H16-0584-25 - Land off Monks House Lane

From: Hill, Grace <Grace.Hill@e-lindsey.gov.uk>
Sent: 19 August 2025 13:45
To: Niland, Mark <Mark.Niland@sholland.gov.uk>
Cc: De-Ruyck, Chris (ELDC) <Chris.De-Ruyck@e-lindsey.gov.uk>
Subject: H16-0584-25 Ecology Comments

H16-0584-25 - Land off Monks House Lane Spalding PE11 3LH

Hybrid application: Full planning application for the erection of 160 dwellings and associated infrastructure, demolition of existing buildings and outline planning application for the erection of up to 274 dwellings. Summary: We are confident that 10% biodiversity net gain can be achieved for this site through a combination of onsite habitat creation and securing offsite units. The authority should secure the on-site habitat creation and HMMP via a S106 planning obligation due to the significant increase of onsite habitat units through tree planting and grassland creation.

Baseline Habitats

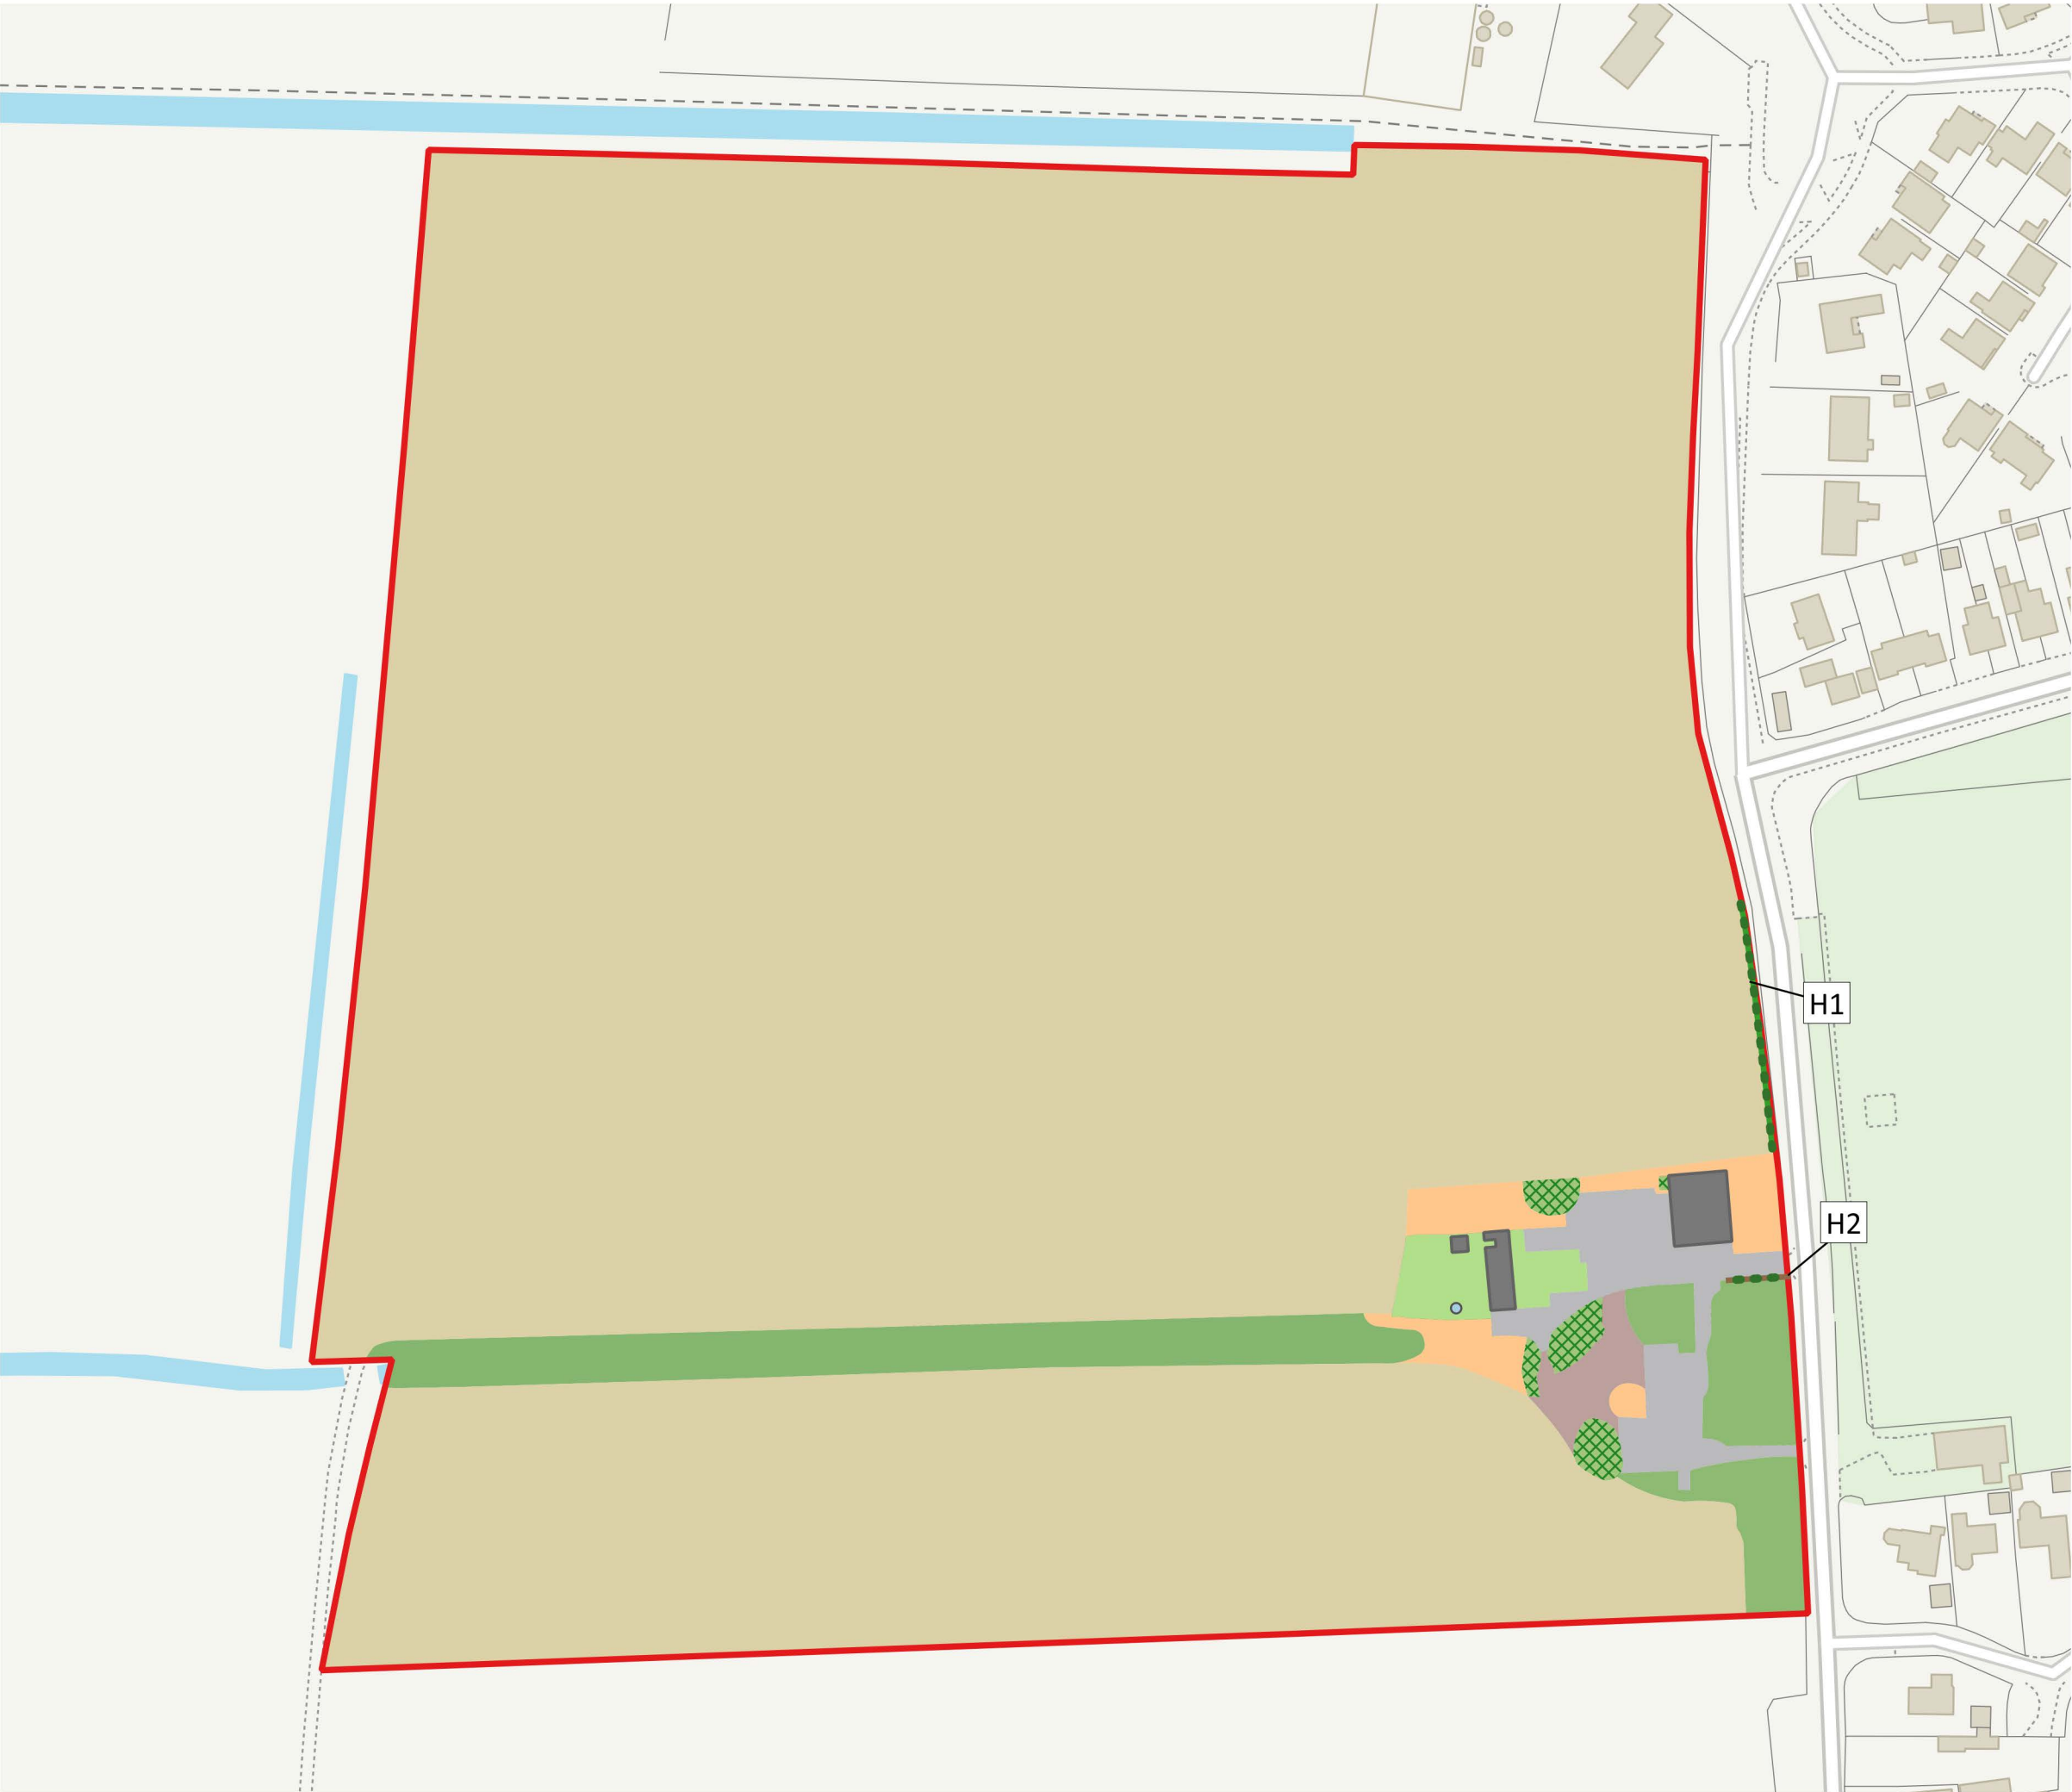
- Due to the suitability of the baseline habitat for ground nesting birds, we require the following wording to be included as a dispatch condition:
 - *"Vegetation should be cleared outside of the main bird nesting season (March to August inclusive) where possible. If works are justifiably required during the nesting season, then a nesting bird check/habitat inspection should be undertaken prior to work by an ecologists within 24 hours prior to clearance to ensure that there is not nest disturbance within the site. Any active nests discovered during inspections will be protected with a suitable exclusion buffer (of appropriate size to the species) to prevent disturbance and monitored until the nest is*

- As the proposed development will need to demolish three buildings, we request that the following working be set as a condition discharge to protect any bats during the demolition and development of the site:
 - If bats are found after development work has started, stop all work in that area that is likely to break the law and get expert help from a qualified and licensed ecologist. Then conduct a survey, develop a mitigation plan, and apply for a bat mitigation license if required.*
